Planning Ref: NA29N.314724

RE: NA29N.314724 - Railway (Metrolink - Estuary to Charlemont via Dublin Airport) Order [2022]- Oral Hearing – The Heritage Council Statement

Drawing Title
Figure 9.5 St Stephen's Green in Relation to Other Public Transport Facilities
Sheet 14 of 15

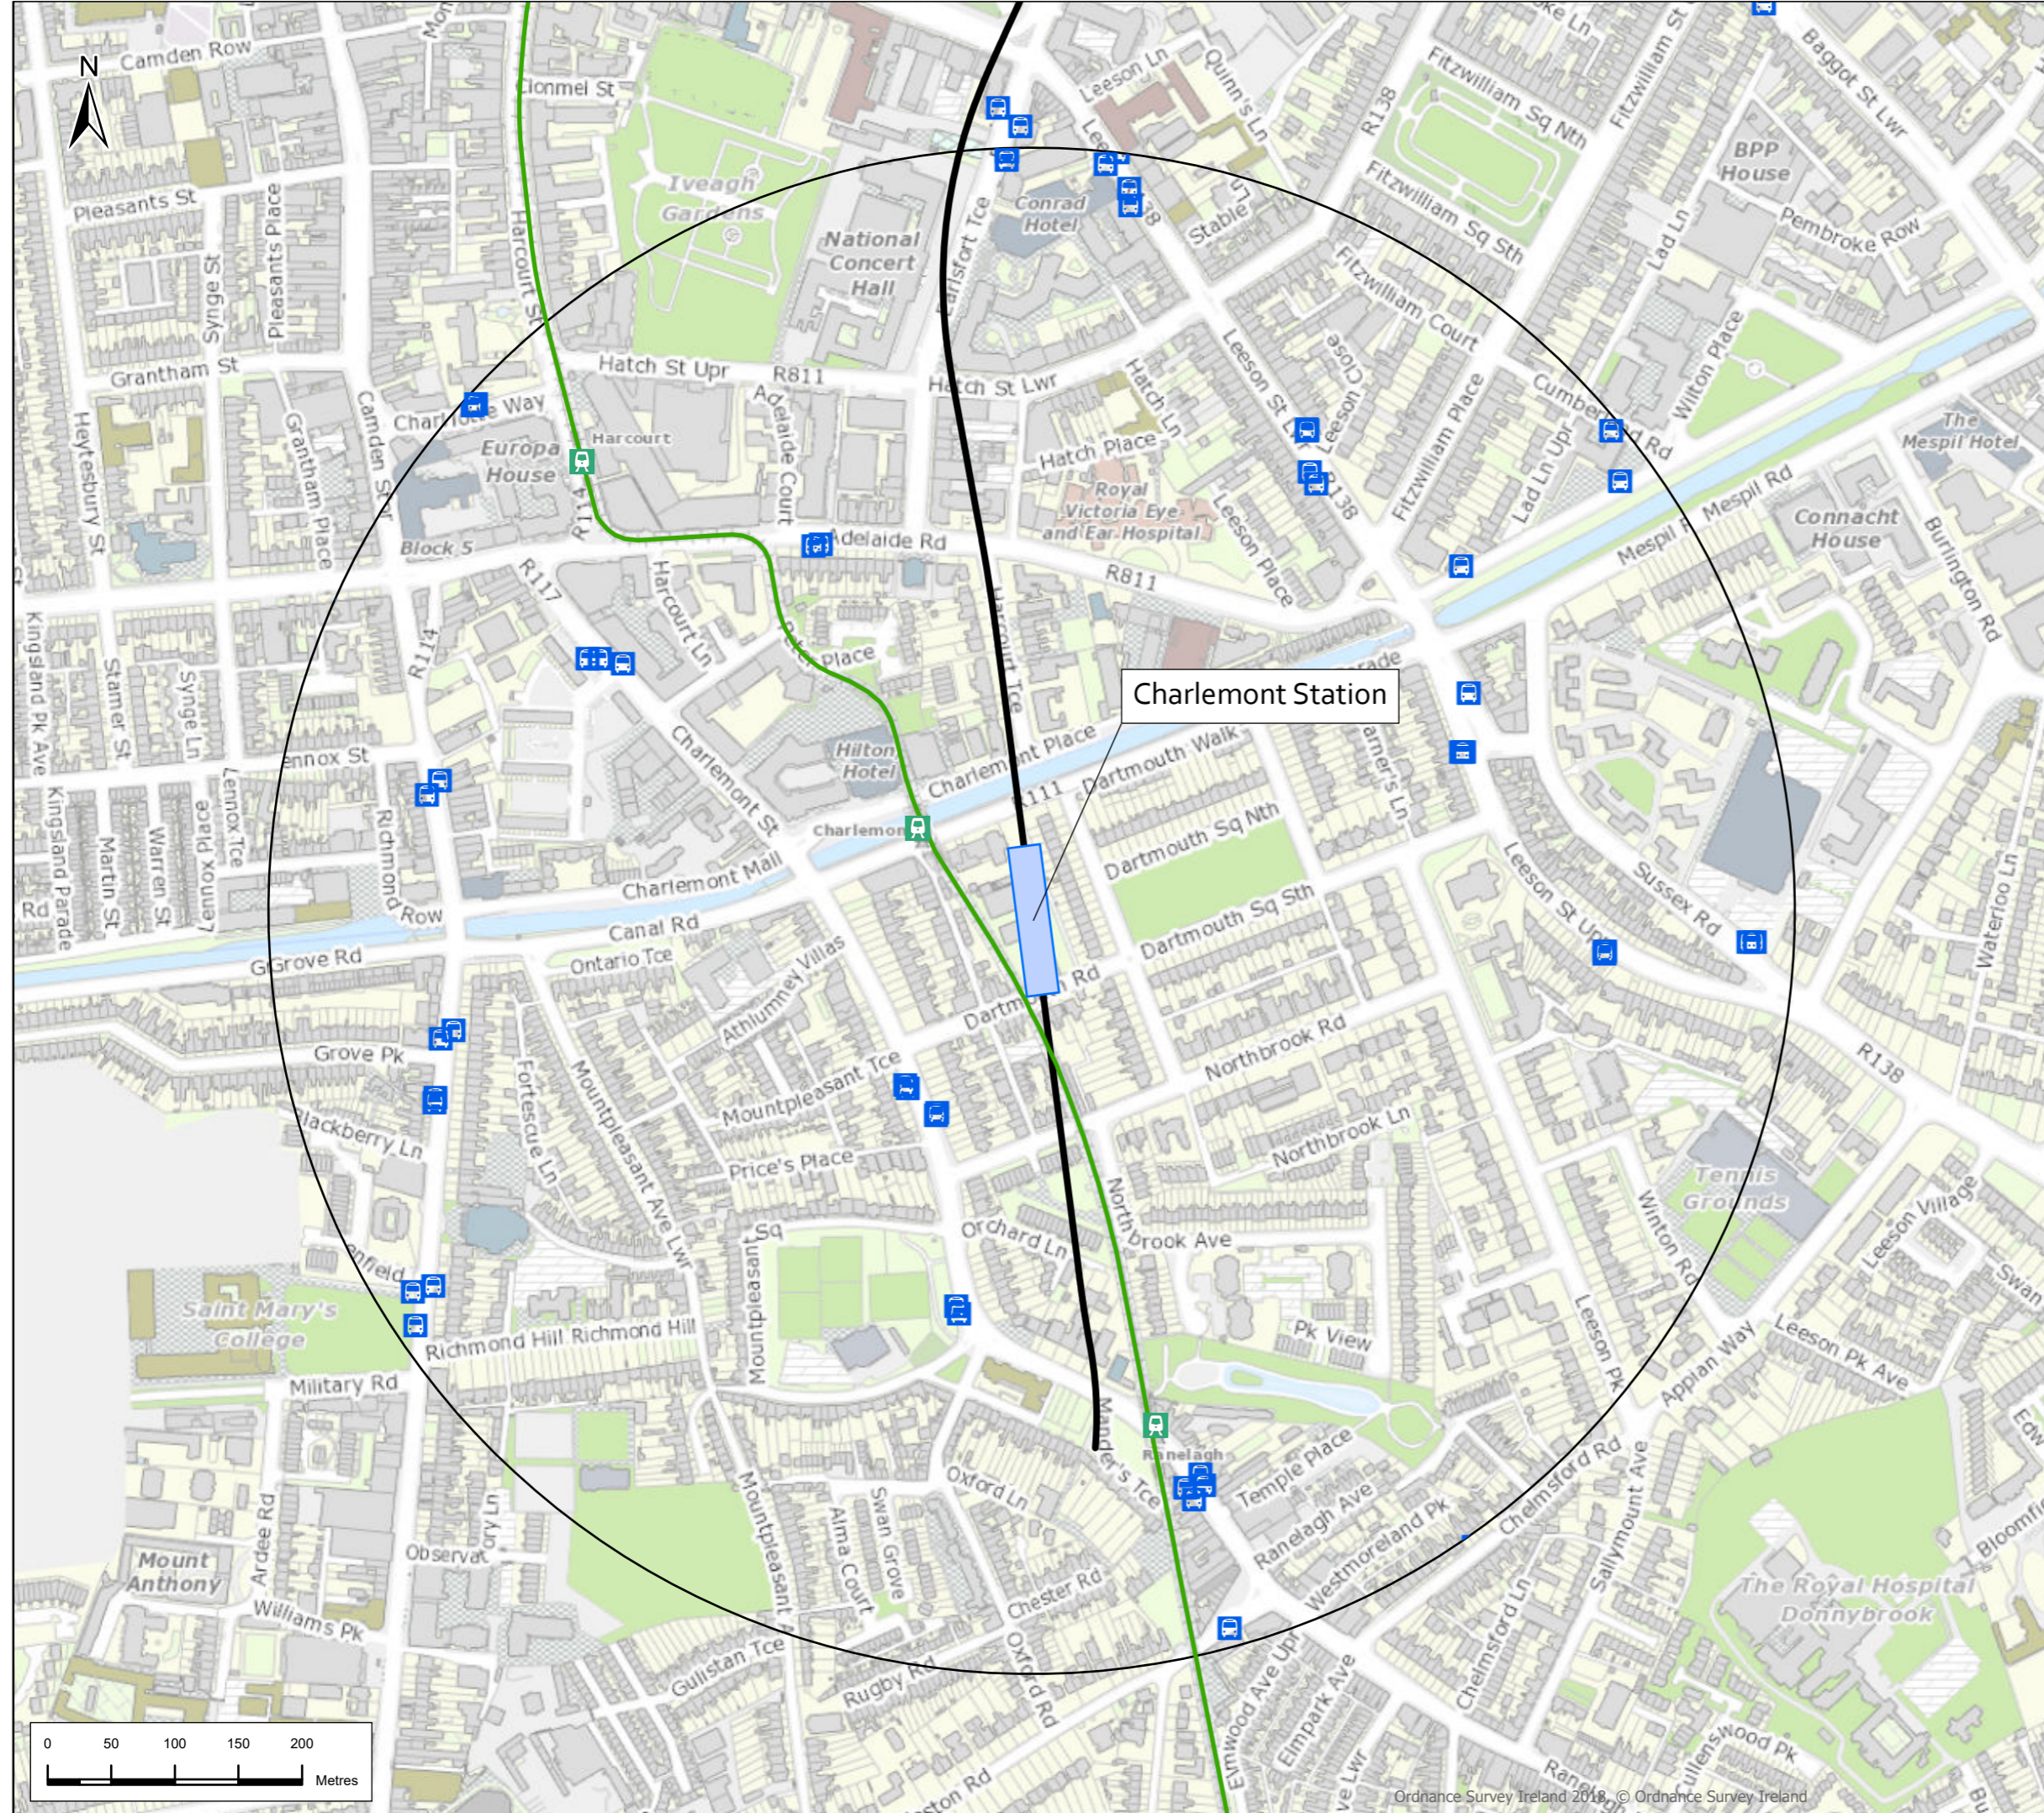
The Heritage Council notes that St. Stephen's Green is of national importance in terms of its cultural, built and ecological heritage. The Department of the Environment, Local Government and Heritage, and the Office of Public Works (OPW) have expressed concerns about the impact of the proposed scheme on the heritage asset that is St Stephen's Green. The Heritage Council notes, and shares, their concerns.

- Immediate and irretrievable loss of mature trees (64 to be felled) and vegetation removed to the east of the park.
- Removal of the park railings, Wolf Tone Monument and Famine Sculpture, – to be stored and relocated in a new location or replaced at existing locations.
- Smoke and ventilation exhaust vents inside the railings, therefore in the park.
- Station entrance at the northeastern corner of the park (removal of monuments as noted above).
- Other aboveground elements (passenger lift, fire brigade lift and vents), some of which are outside park (but these still influence the setting, being immediately adjacent).

- Plinth walls – (195 metres of wall and rail temporarily removed), along with two pedestrian gateways, six traditional-style lamp posts, fifty granite bollards outside the park railings and lengths of railing at the park entrances and at the margin – to be removed and reinstated.

In terms of the **operational phase** - the introduction of a new entrance to the Metrolink station within the park; pop-ups (ventilation shafts etc); the repositioning of monuments; and the alterations to the landscaping, represent permanent changes to the setting of the park and the impact has been considered **very significant**. The OPW have correctly identified this and emphasise that the Green is a square park, and this is how it is viewed from an historical, architectural, landscape and cultural heritage perspective. Therefore any 'chipping' away of the park, however small will naturally have impact the Green's integrity.
